**Project Name: \*** Widening of I-95 to Eight lanes from South of SR 1832 (Murphy Road – Exit 56) to South of SR 1811 (Bud Hawkins Road – Exit 70)

## I-5986A 4C Interagency Concurrence Point Meeting Minutes

An interagency concurrence point meeting was held in order to reach agreement on concurrence point 4C for the I-5986A I-95 widening project in Cumberland County. The following items were discussed and conclusions reached:

PROJECT REFERENCE NO.		SHEET NO.	
1-5986A		54	
R/W SHEET NO.			
ROADWAY DESIGN ENGINEER		HYDRAULICS ENGINEER	
INCOMPLETE PLANS DO NOT USE FOR R/W ACQUISITION			
DOCUMENT NOT CONSIDERED FINAL UNLESS ALL SIGNATURES COMPLETED

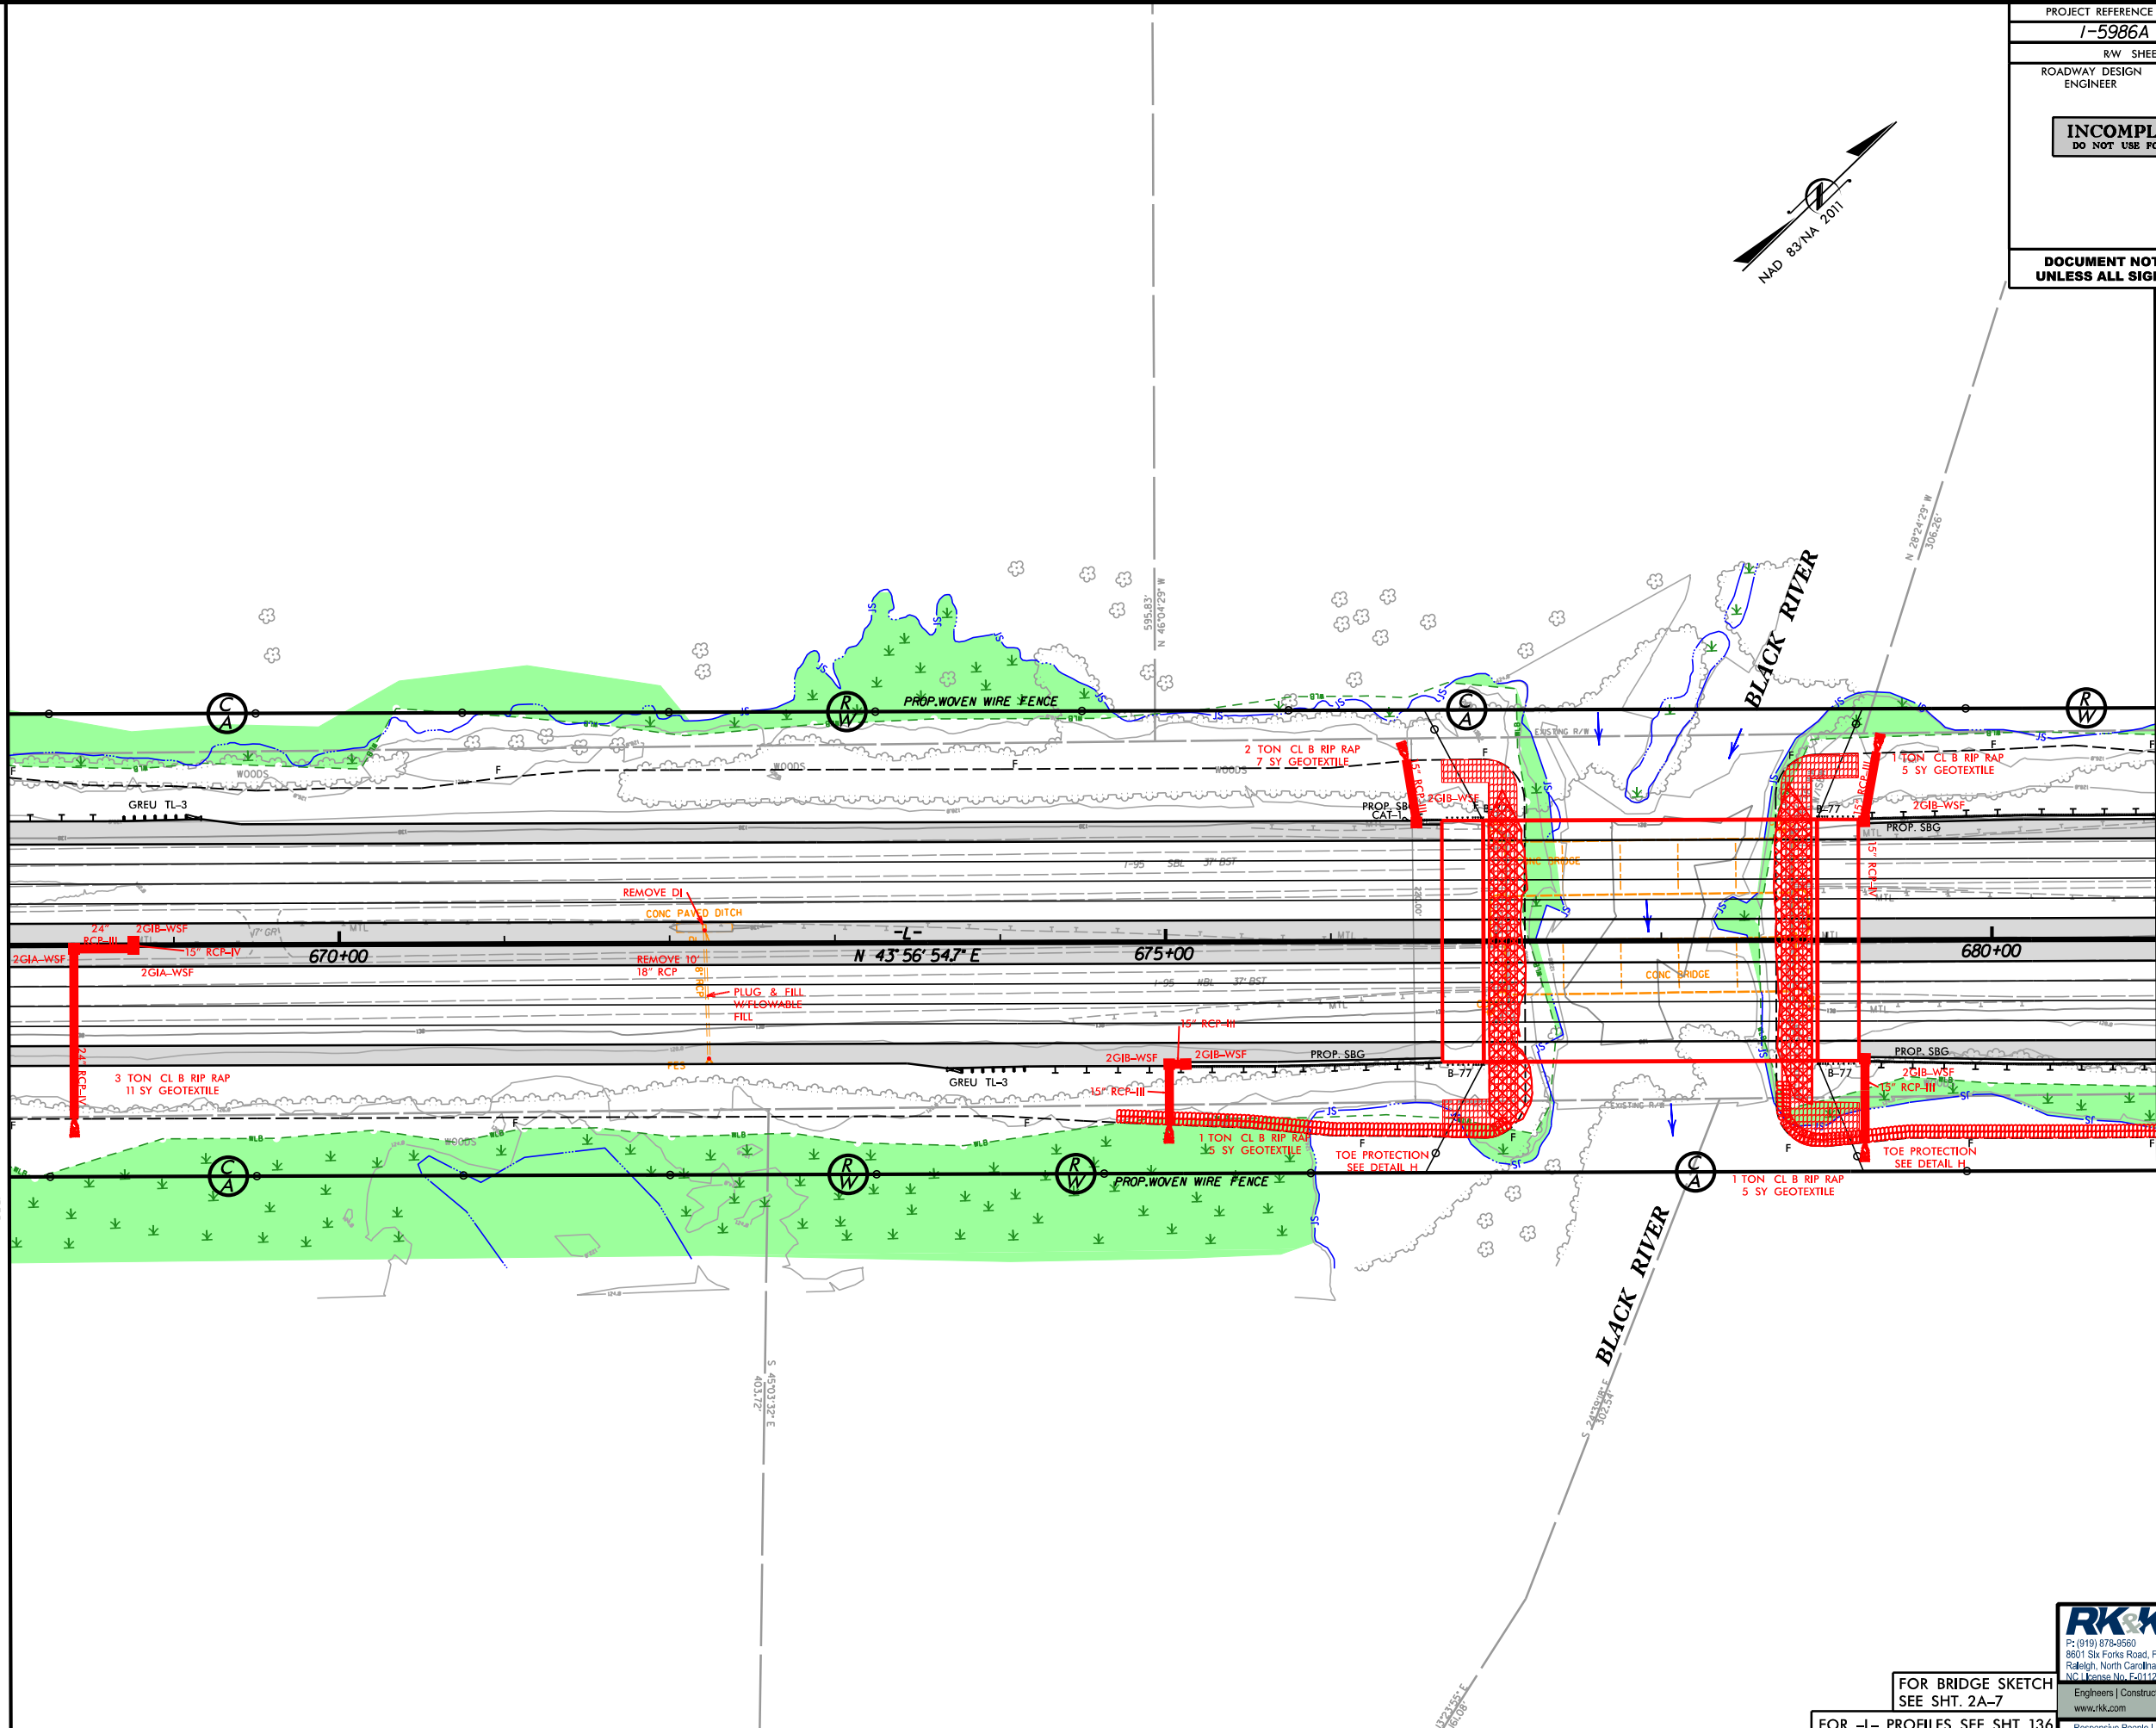
- **Site 23:** Stream SC-1, SC-2. Impacts due to proposed 2 @ 8'x8' RCBC and channel ties. The RCBC is buried 1.0' with a 1' sill in the right cell.

PROJECT REFERENCE NO. 1-5986A		SHEET NO. 36	
RW SHEET NO.			
ROADWAY DESIGN ENGINEER		HYDRAULICS ENGINEER	
DOCUMENT NOT CONSIDERED FINAL UNLESS ALL SIGNATURES COMPLETED			
PERMIT DRAWING SHEET 79 OF 163			
REVISED 1/26/2022

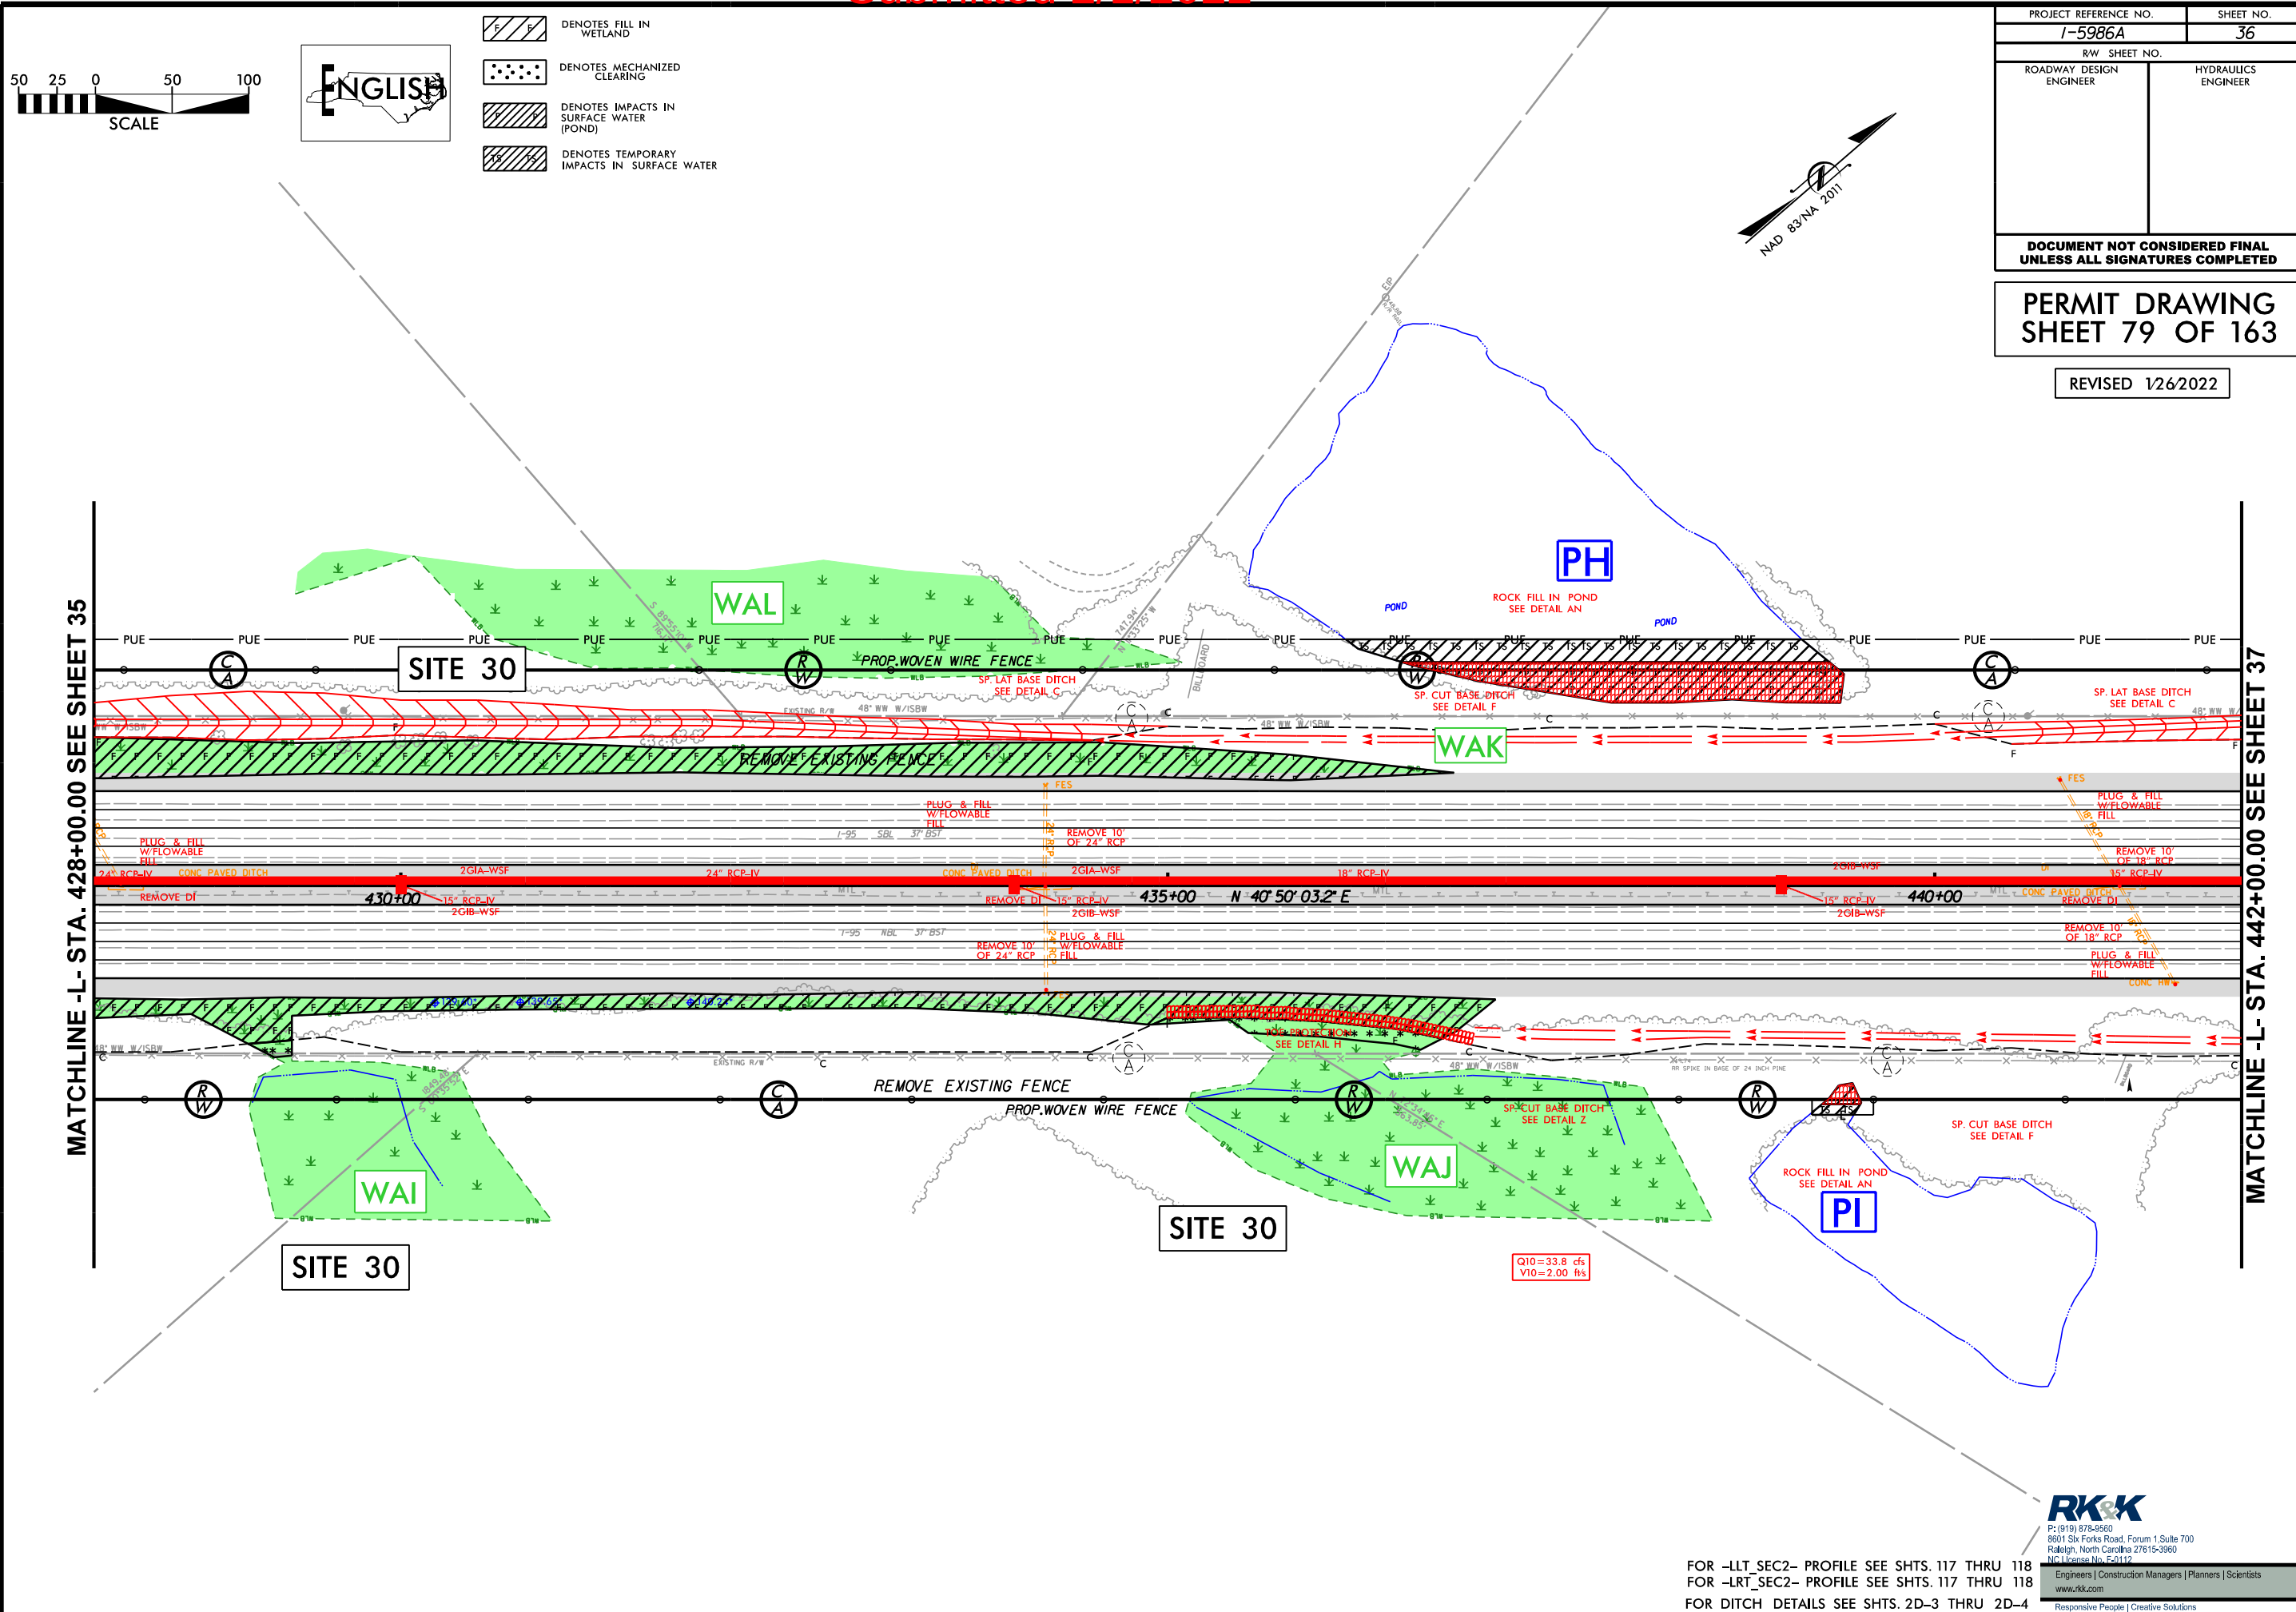
- **Site 13:** Wetland WR. Impacts due to proposed roadway fill.
- **Site 14:** Wetland WR. Impacts due to proposed roadway fill and ditch.
- **Site 15:** Wetland WO. Impacts due to proposed roadway fill and 54" WS pipe. The 54" WS pipe will be installed 1' higher than the invert of the existing 42" RCP at this location to serve as an overflow pipe. Stream Baker Swamp-2 is impacted by a 66" RCP (not buried), at this site as well but is reflected on drawing 43.
- **Site 16:** Stream Baker Swamp-1; wetland WN. Impacts due to proposed 54" WS pipe. The 54" WS pipe will be installed 1' higher than the invert of the existing 42" RCP at this location to serve as an overflow pipe.
